Appeal Decision

Appeal Ref: APP/T2350/D/14/2213900

Neddy Barn, Neddy Lane, Billington, Lancashire, BB7 9ND

- The appeal is made under section 78 of the Town and Country Planning Act 1990 against a refusal to grant planning permission.
- The appeal is made by Ms Louise Entwistle against the decision of Ribble Valley Borough Council.
- The application Ref 3/2013/1013, dated 22 November 2013, was refused by notice dated 3 February 2014.
- The development proposed is to increase the height of the existing barn arch opening.

PROPOSED ALTERATIONS TO
 FRONT ELEVATION
 NEDDY BARN
 NEDDY LANE
 BILLINGTON

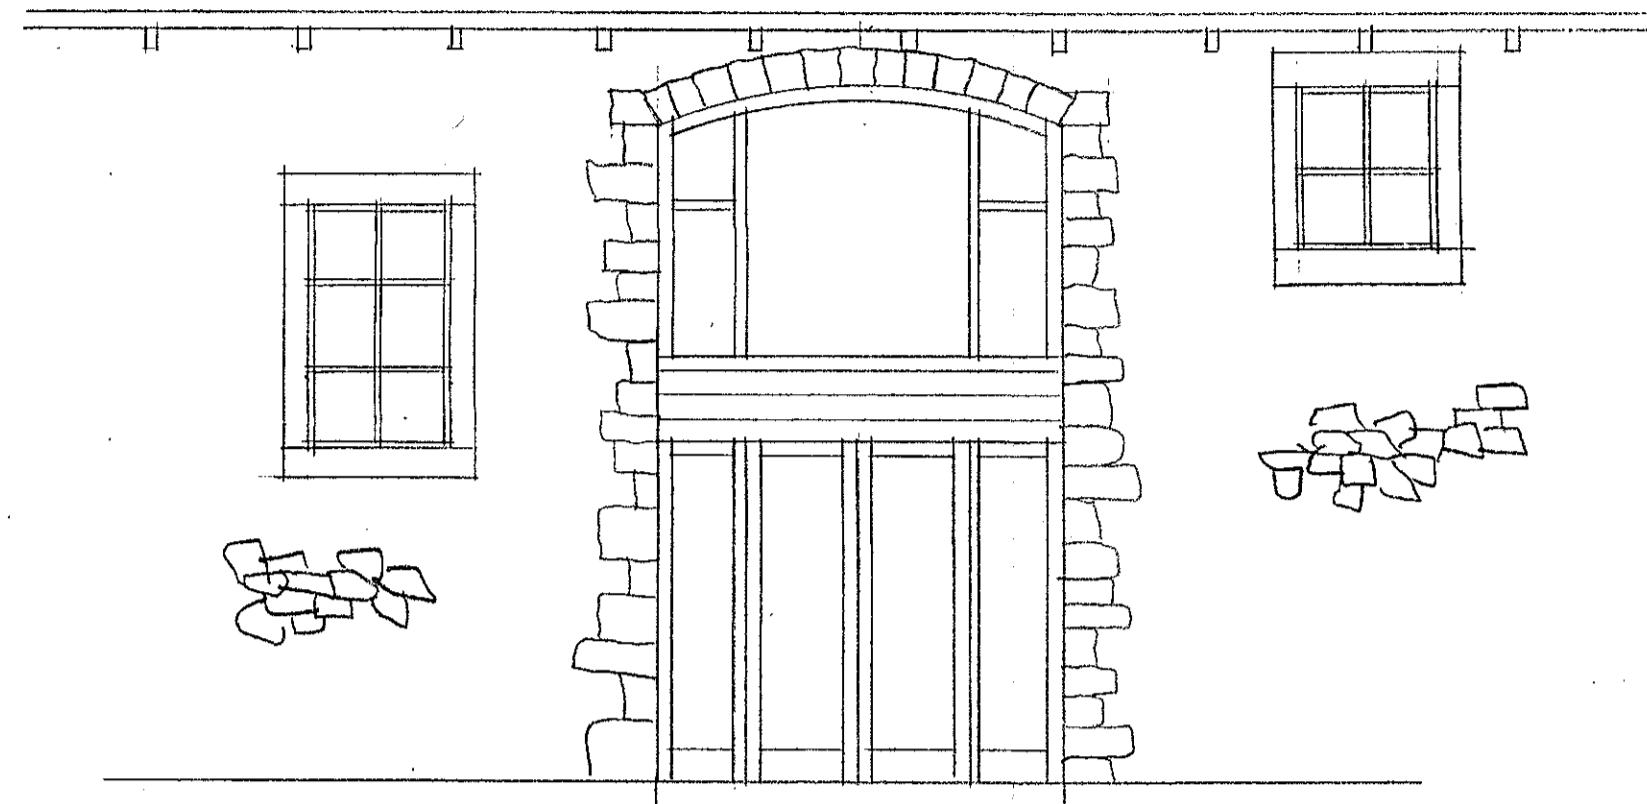
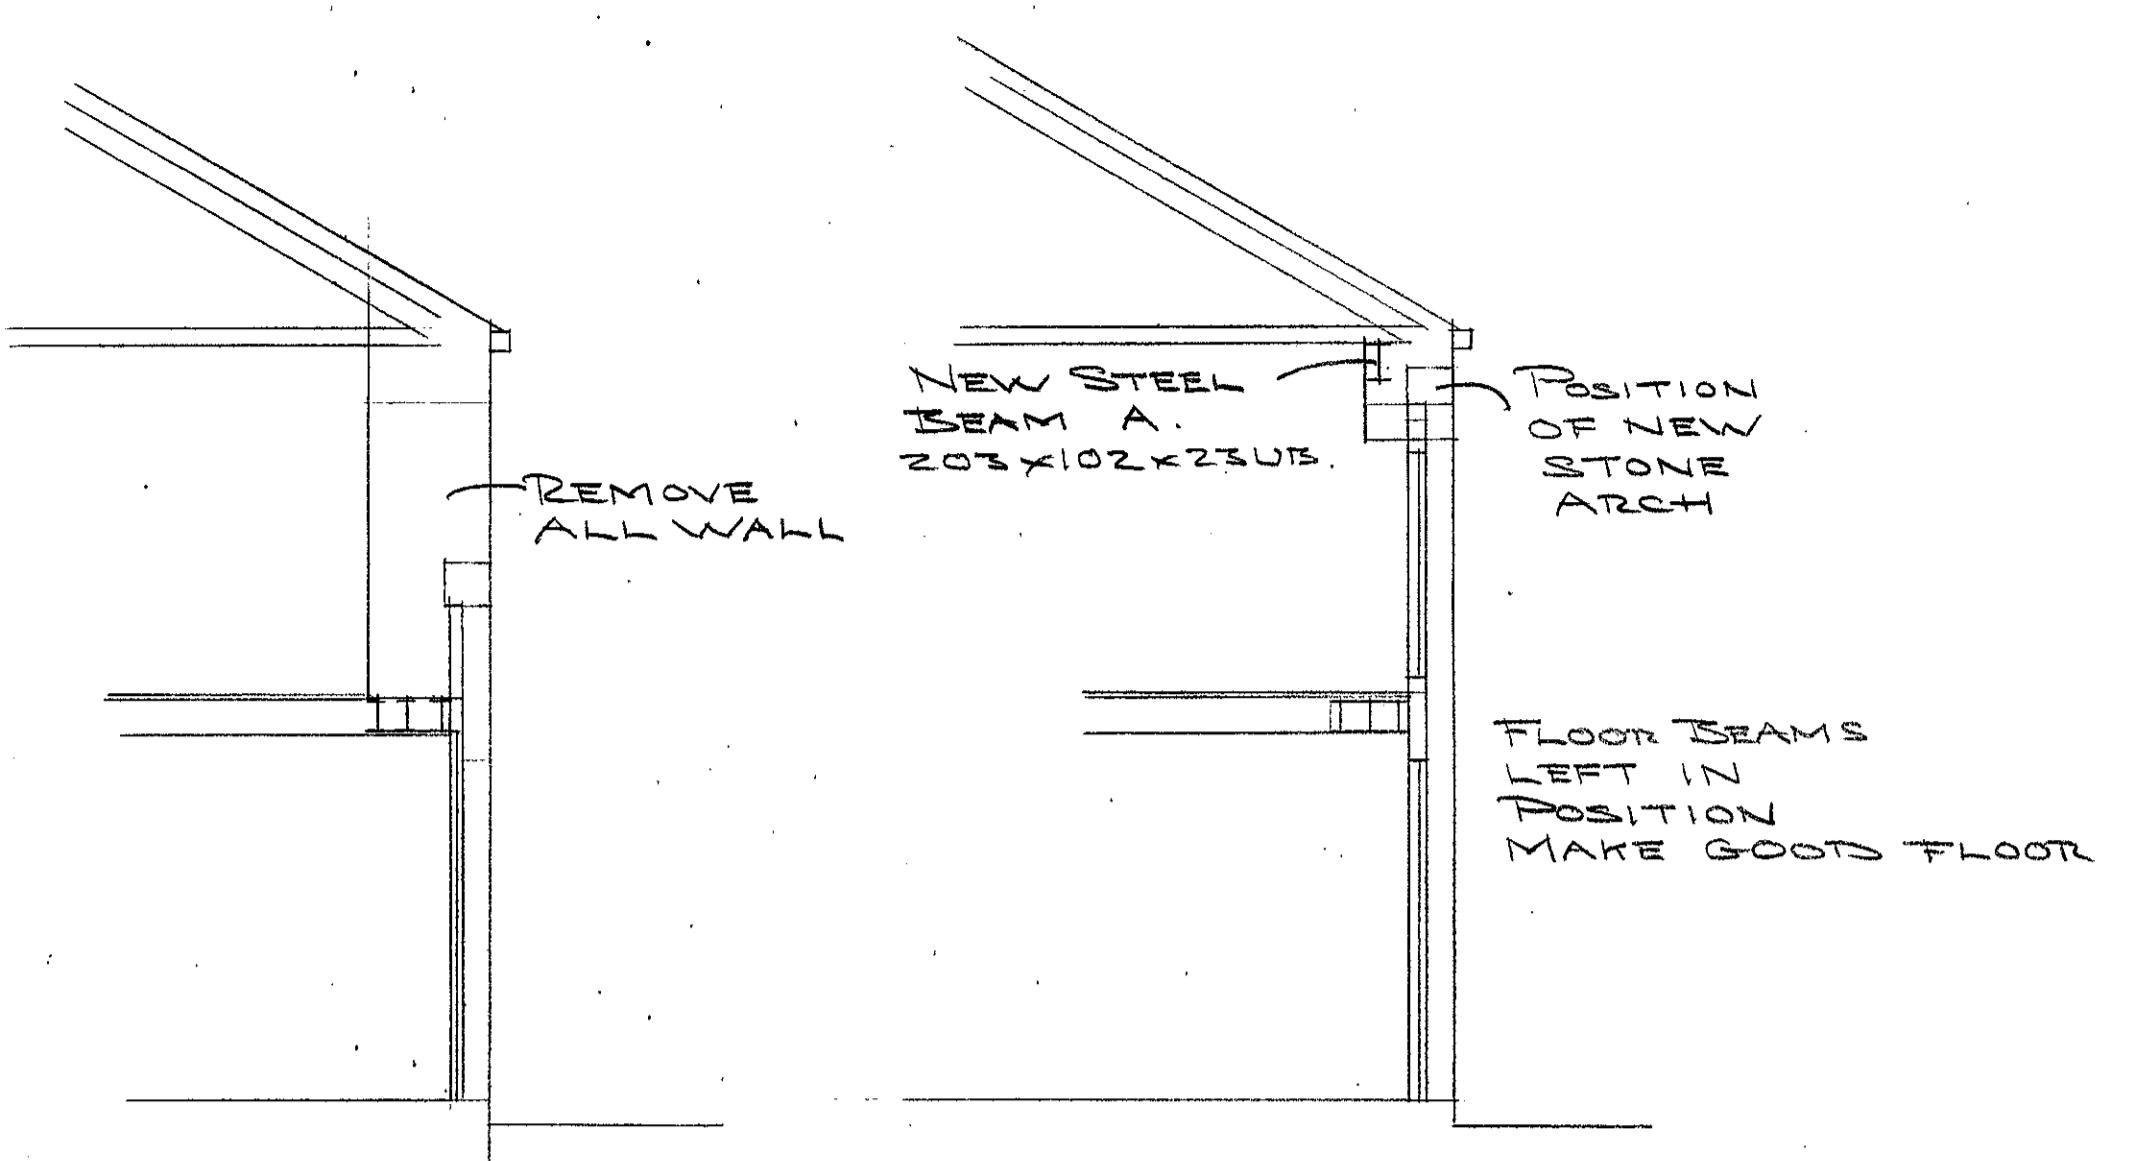
3. The appeal proposal would increase the height of the existing barn arch opening from roughly 3.6m to approximately 4.8m, taking it to a position just below the eaves. Given that this arched opening is likely to be an original feature of the converted barn I appreciate the Council's concerns that altering it could change the legibility and character of the building. The introduction of additional glazing flush with the east-facing elevation would also be likely to reflect more sunlight during certain parts of the day and increase the prominence of the alteration.

4. However, the barn and its immediate neighbour are substantial stone buildings and their traditional, functional form and appearance are clearly evident. As a result, I am not persuaded that increasing the arched opening by only roughly 1.2m would create an unduly prominent feature sufficient to detract from this appearance, or cause any harm to the robust character of the building. For the same reasons, although the arch would extend to almost the eaves, it would not be out of proportion.

5. Furthermore, whilst the appeal property and its immediate neighbour have both been completed to a high standard and openings kept to a minimum, they do nonetheless contain domestic features such as the row of first floor windows adjacent to the arch and the roof light above it. Given the proximity of these features to the arch, the introduction of slightly more glazing would not be an unsympathetic or harmfully incongruous addition either.

1. The appeal is allowed and planning permission is granted to increase the height of the existing barn arch opening at Neddy Barn, Neddy Lane, Billington, Lancashire, BB7 9ND in accordance with the terms of the application, Ref 3/2013/1013, dated 22 November 2013, subject to the following conditions:
 - 1) The development hereby permitted shall begin not later than three years from the date of this decision.
 - 2) The development hereby permitted shall be carried out in accordance with the following approved plan: Proposed Alterations to Front Elevation.
 - 3) The materials to be used in the construction of the external surfaces of the alterations hereby permitted shall match those used in the existing building.
